Falcon Meadows at Bent Grass
Filing No. 3
Transportation memorandum
(LSC #S214332)
April 15, 2022

PCD File No
SF2216

RE: Falcon Meadows at Bent Grass Filing No. 3
El Paso County, CO
Transportation Memorandum
LSC #214332

Figure 3  
**Sight Distance**

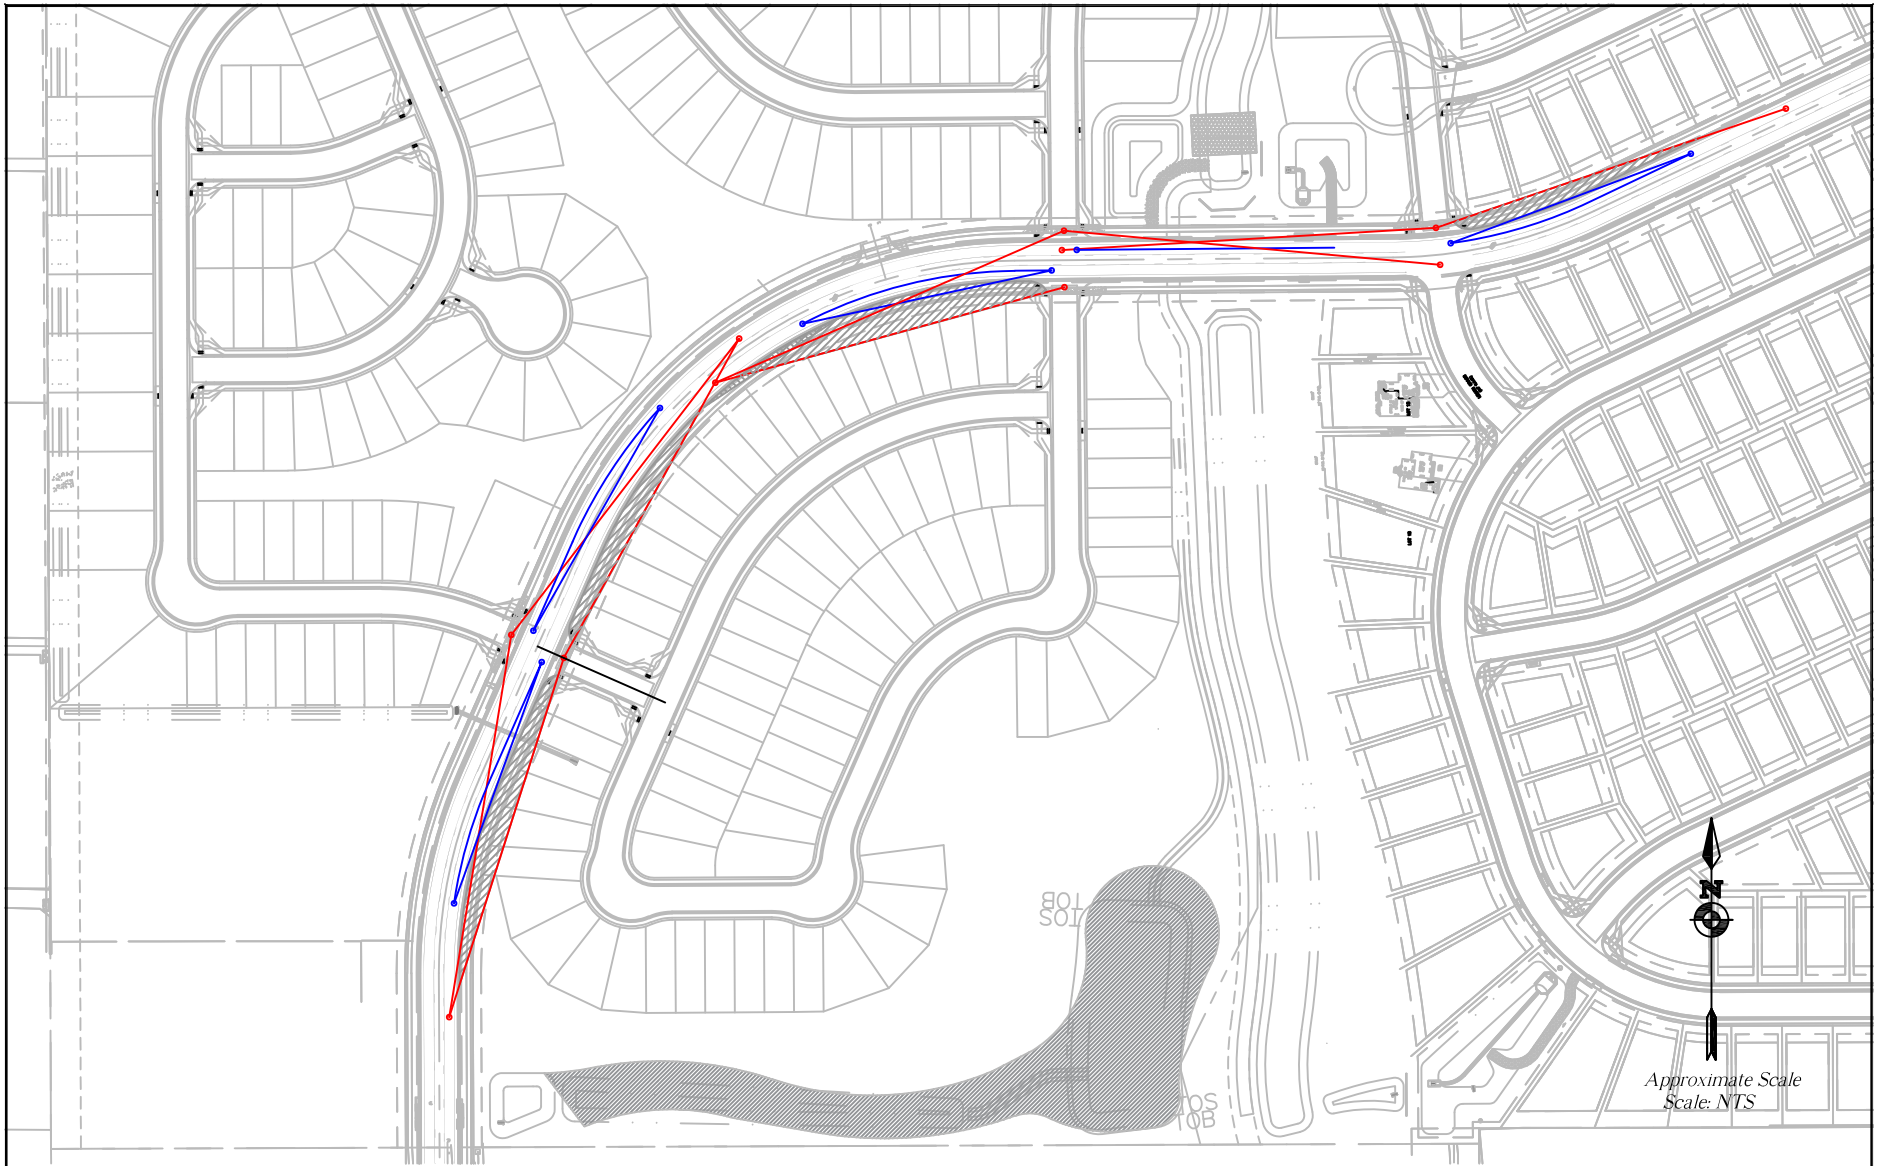
The two access points to Bent Grass Meadows Drive are part of Filing 2. Please revise the narrative to reflect that.
